Further drainage consultation response AL/28/20/DOC

Thank you. I confirm points 1-7 are now closed. I await further detail regarding points 8-11.

P4	11.09.19	AMENDED TO SUIT WSSC COMMENTS.	PJM
P3	15.07.19	NOTE TO TELEPHONE POLE ADDED.	JMB
P2	01.07.19	EXTENT OF WORKS AMENDED.	JMB
P1	14.06.19	PRELIMINARY ISSUE FOR COMMENT	JMB
Revision	Date	Description	By

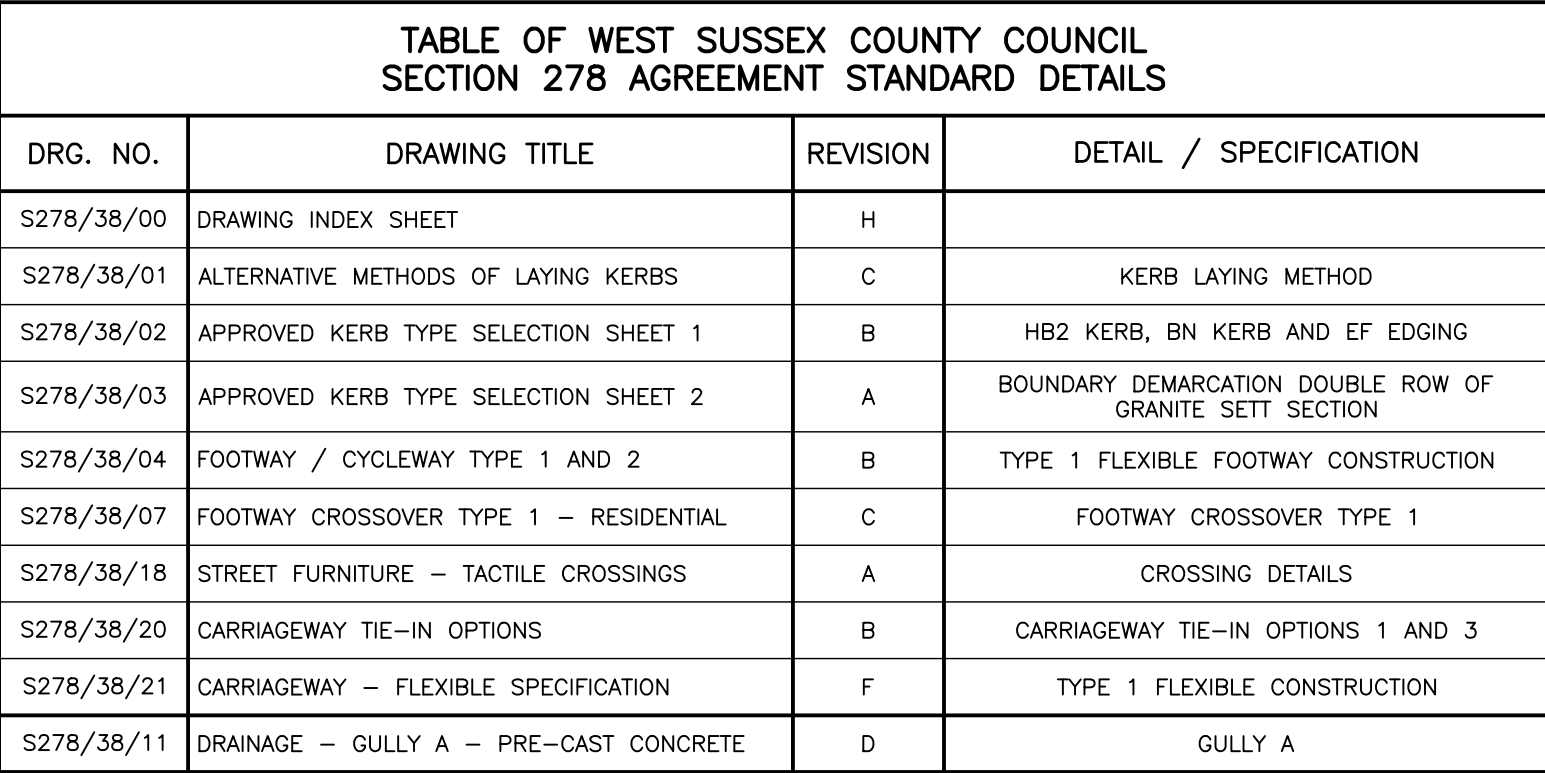
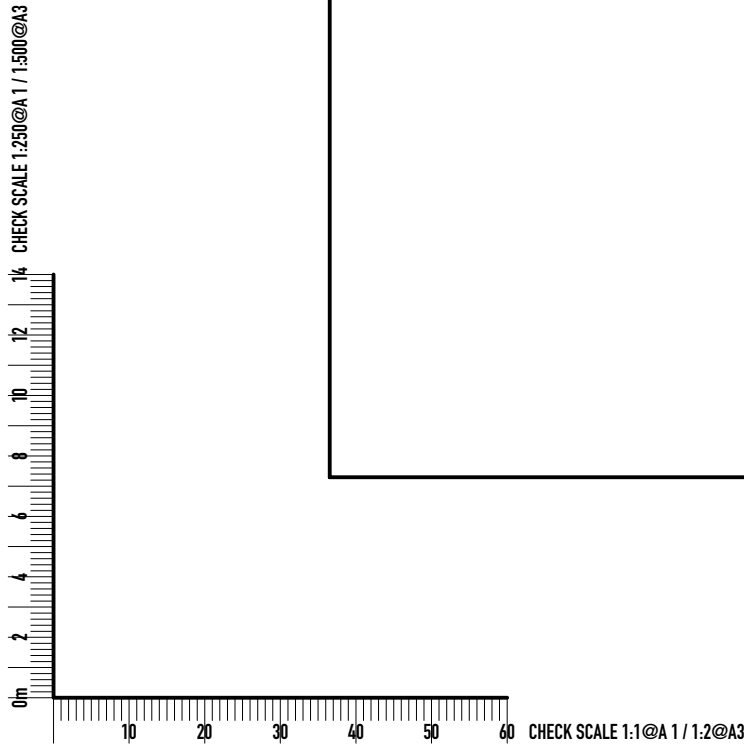
1. Soakaways 4 to 10 appear to have their bases set below peak recorded groundwater level. Please raise the bases of these soakaways. Please check the model and the accompanying drawing we've provided again. You will see that although these soakaway bases were set below the groundwater level, the model has only assessed these from the effective level, equivalent to the peak groundwater level.

2. There are large inconsistencies between the pipe network shown on plan and that modelled, with invert and cover levels of manholes not tallying. Of those checked (circa 15) none were consistent, please correct. The cover levels were approx. 50-150mm off as were indicative in some places and have been revised, this has not had any negative effects as system is working well. The invert levels are manually set on the Causeway Flow model to tally with the Arch Associates Drainage and Road Layout & details drawings. I have revised the inverts slightly of 6 out of 130 nodes, all now tally, please see revised accompanying model drawing to check these so this should be clear. Please revisit this.

3. Soakaway 16 has inconsistent dimensions between calculations and plan, please correct. The plan shows this soakaway as 26x12m whilst the calculations showed it as 26x10m. Now corrected and will further improve situation.

4. The invert level of soakaways 6 to 10 are inconsistent between plans and calculations, please correct. As explained in Point 1.
5. A surcharged outfall should be modelled, with surcharged levels set to top of the bank adjacent to the outfall. It is clear from the model that the system has such good capacity that the pond outfall is effectively un-used, with no discharge to watercourse in the design event. It may be that high groundwater levels or a blockage would result in the need for this outfall in the future but it is unlikely to ever be surcharged.

6. Please supply two perpendicular cross sections of the pond so that modelled dimensions can be verified. Mapledean have provided additional drawing, please see attached. Our model and accompanying drawing shows how we've best fit modelled the pond based on the provided data on the topographic survey, which

7. Please make the hydrobrake construction detail drawing specific to this site, i.e. add invert levels, hydrobrake reference, cover level, etc. Mapledean have provided additional drawing, please see attached. I've detailed the scope of this within the model and accompanying drawing.
8. Within the maintenance manual please detail who will be responsible for maintenance and how it will be funded. Aqua Callidus to address.
9. Please ensure the maintenance manual is specific and only includes elements that are included in design. This should also include reference to smart sponges and the separator. Aqua Callidus to address.
10. Please make maintenance requirements for the flow control device clear. Aqua Callidus to address.
11. Please include details of the landowners riparian responsibility within the maintenance manual. Aqua Callidus to address.

actually accounts for the pond smaller than it is, with an effective base level at the peak groundwater level/outfall level.
